Robert Wiggins
Mill Cottage,
Hallington Mill,
Northumberland.
NE19 2LJ

20th September 2021

Variation of Condition 2 (Approved Plans) for Listed Building Consent 20/02787/LBC

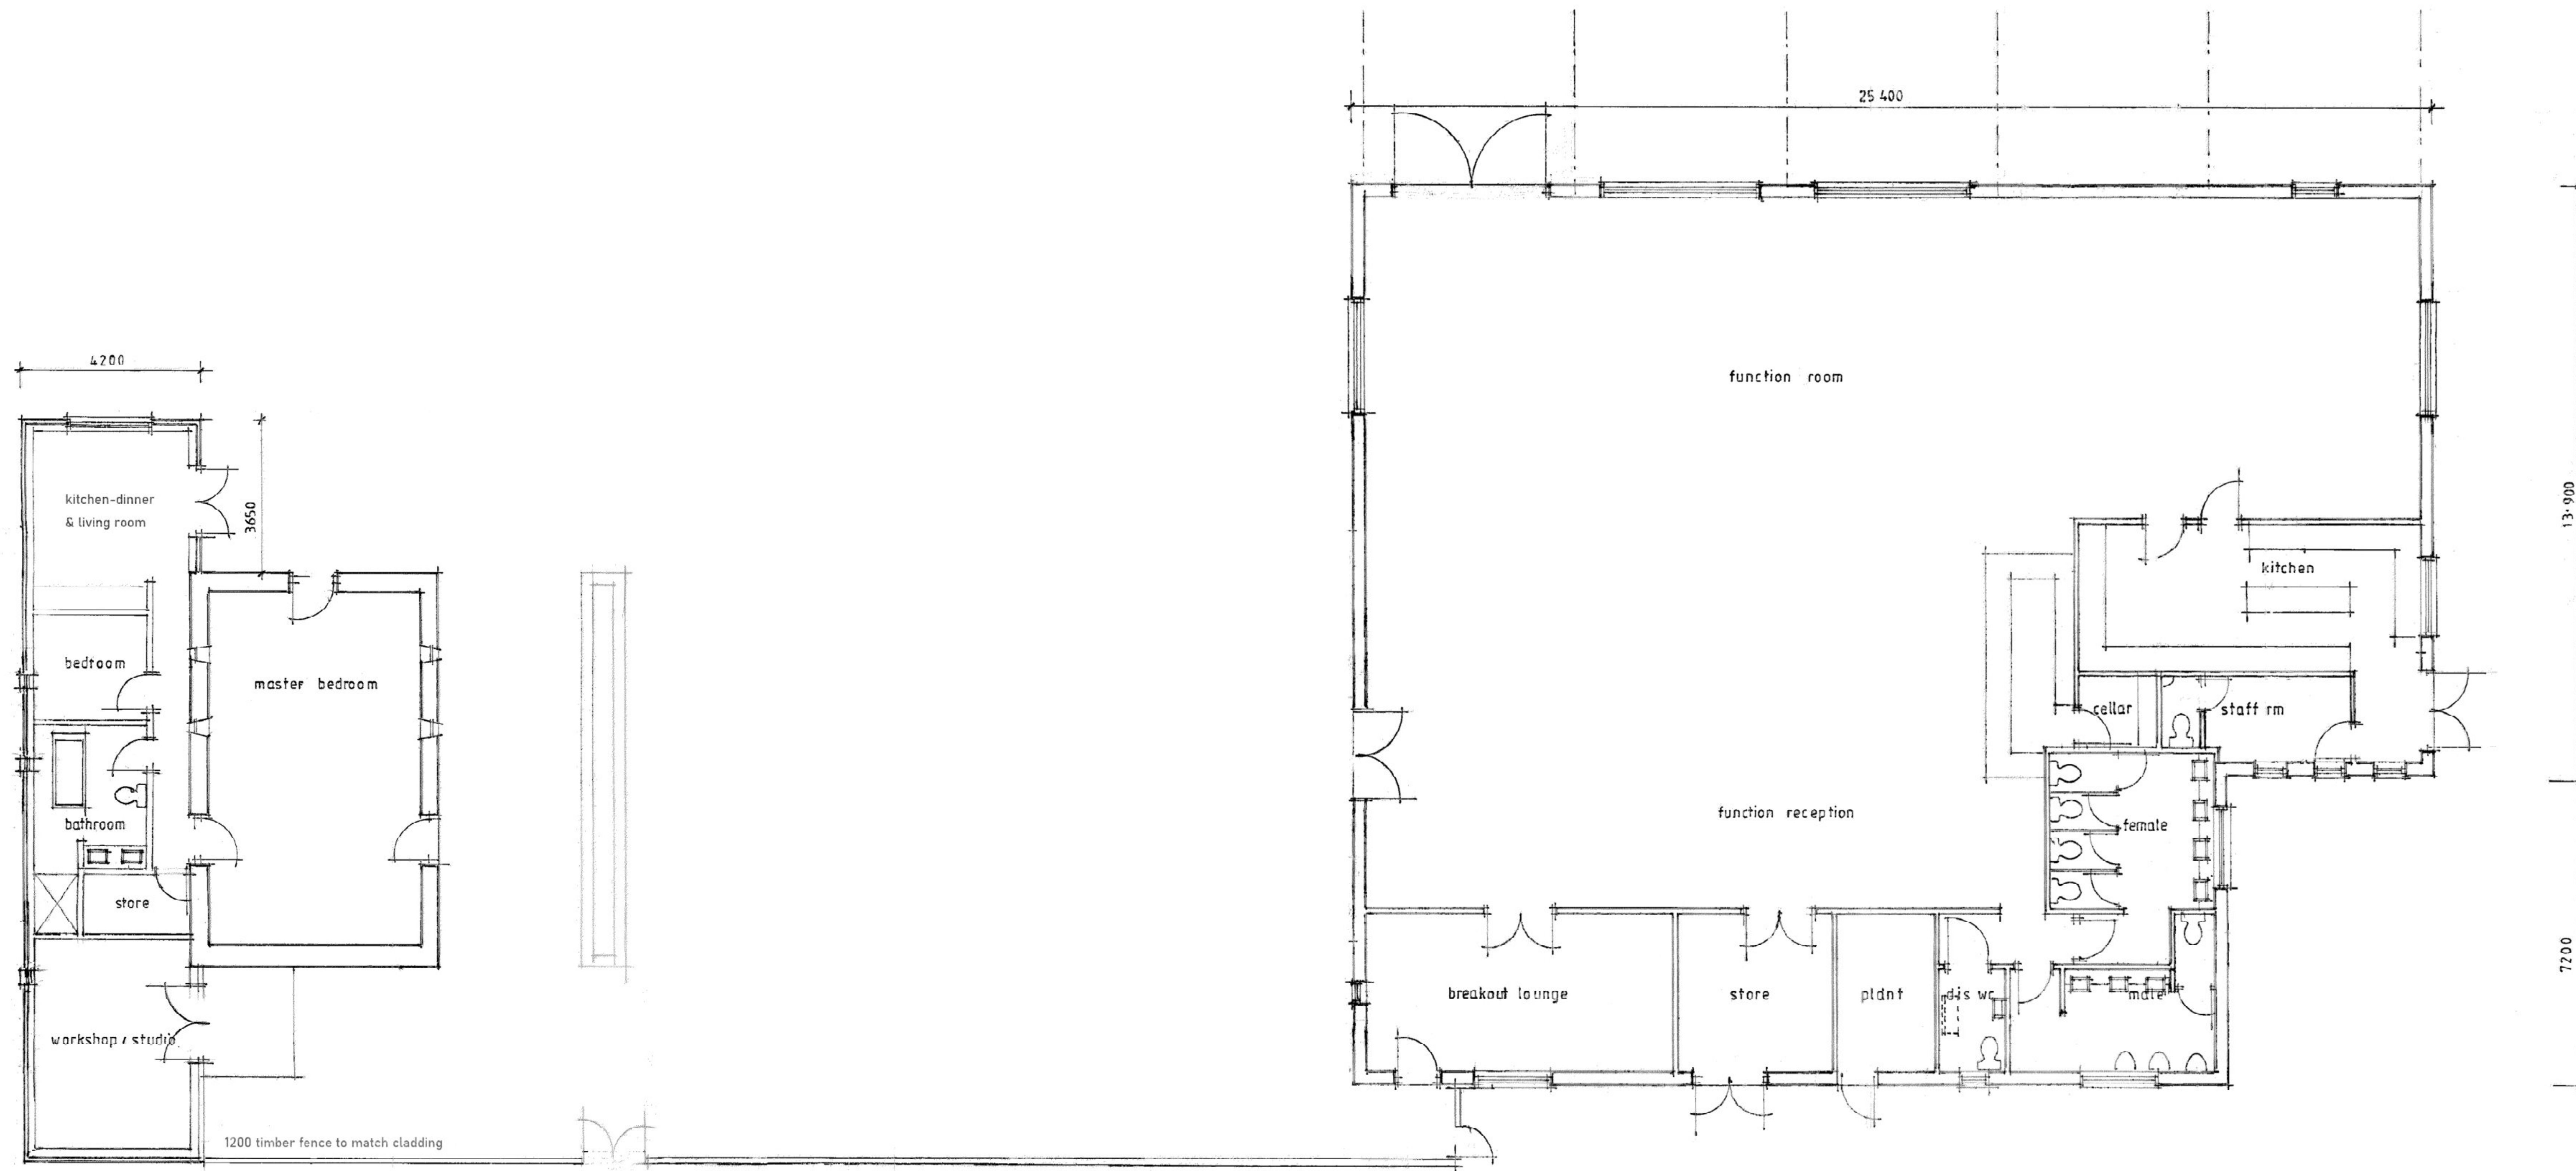
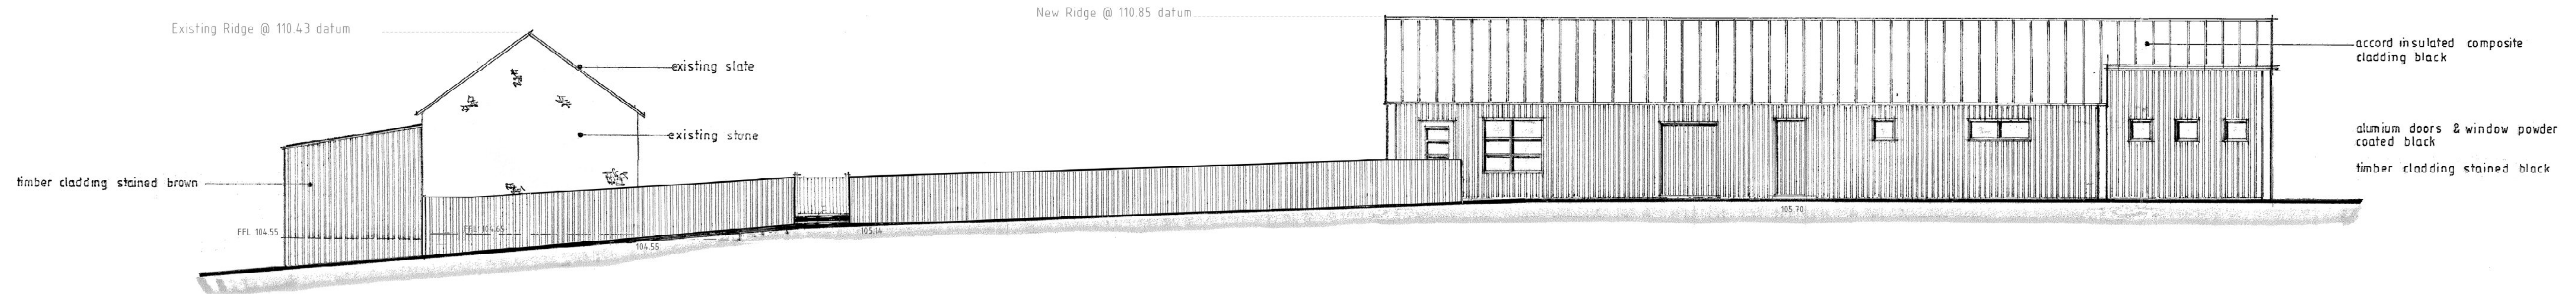
Version 3 Proposed North & South Elevations and Floor Plans

Boundary treatments specifically relating to the stone walls around the Threshing Barn and Courtyard are amended in the updated plan. This now proposes timber fencing in keeping with the external cladding to the Threshing Barn, which will provide a softer and more subservient boundary than the previously proposed stone wall, respecting the dominant form of the historic stone barn. Full details and materials will be provided in the application to partially discharge Condition 8 for 02/02786/FUL.

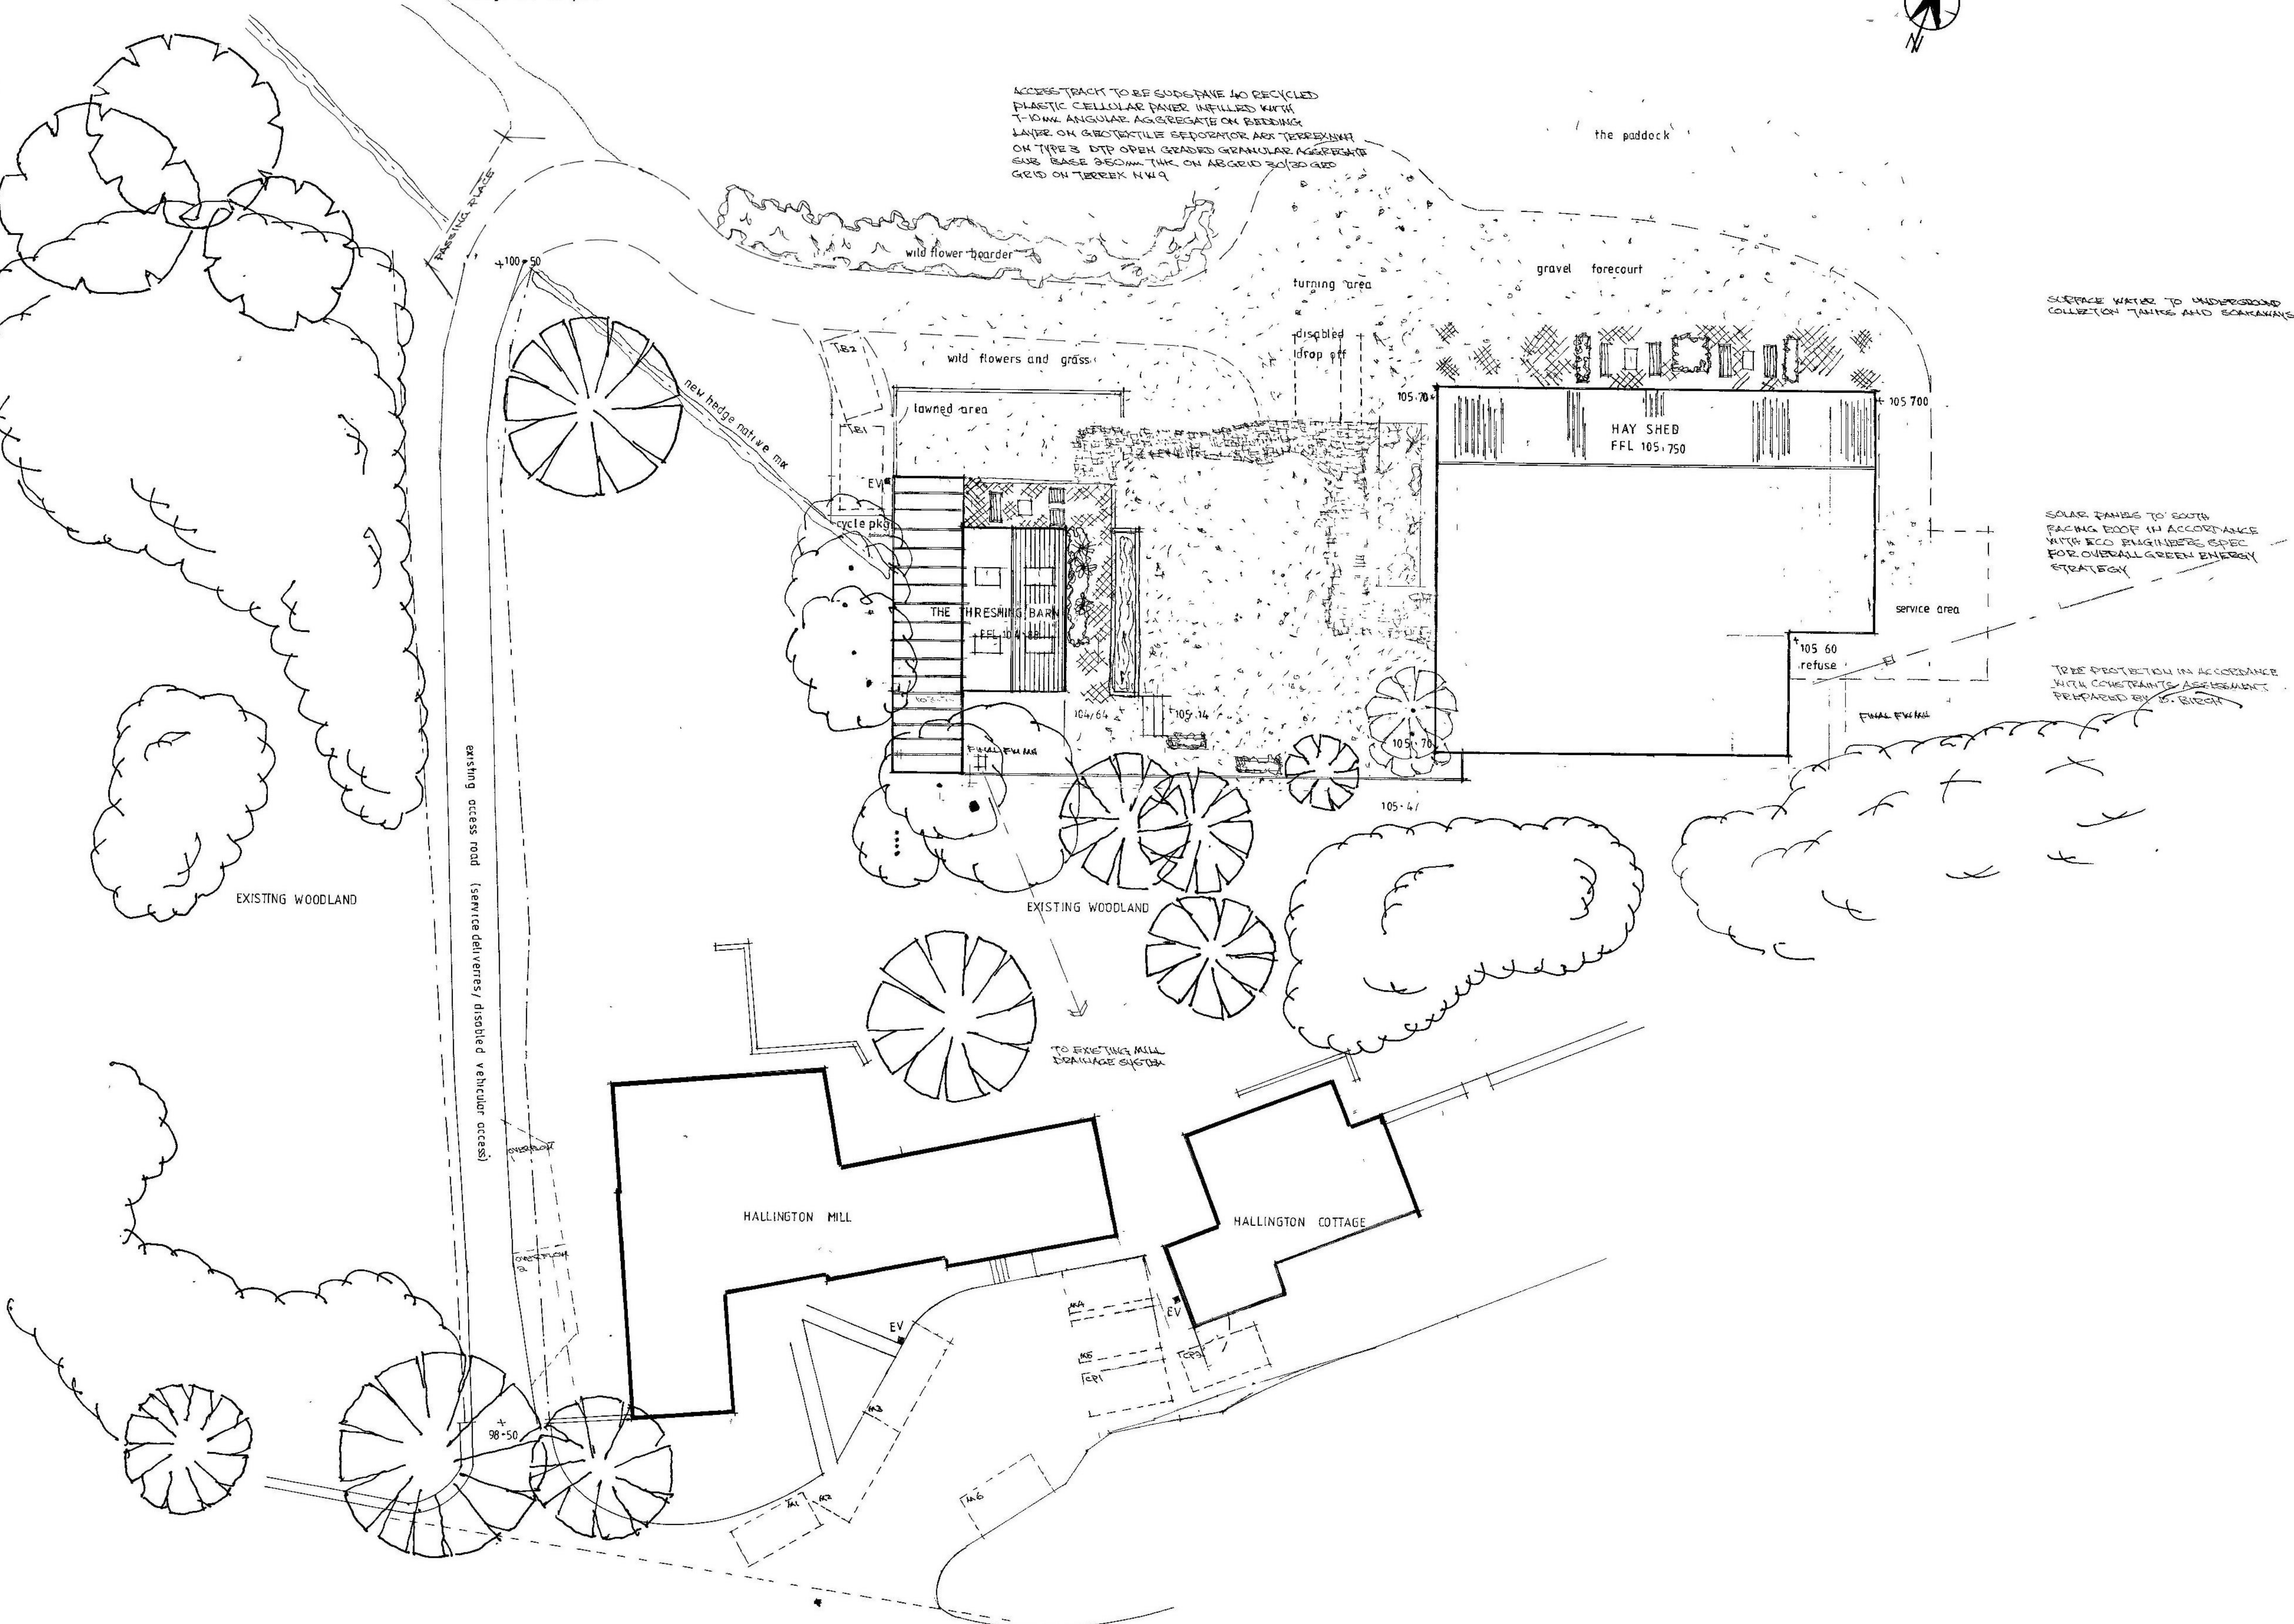
Revision C Proposed Site Plan and Car Parking

An additional car parking space is now shown on the updated plan to the northwest of the Threshing Barn, which will provide for 2 spaces (1 per bedroom) for residents in the Threshing Barn and provide sufficient parking for this unit on a standalone basis. This change does not require any further development works as it simply uses existing space on the Threshing Barn driveway and is aimed at satisfying a variation in Condition 12 of 02/02786/FUL.

A secure cycle parking facility is now provided at the northwest corner of the Threshing barn for residents, consisting of secure locking loop (ground fixed) for 2 bikes. This is aimed at satisfying a variation in Condition 14 of 02/02786/FUL.
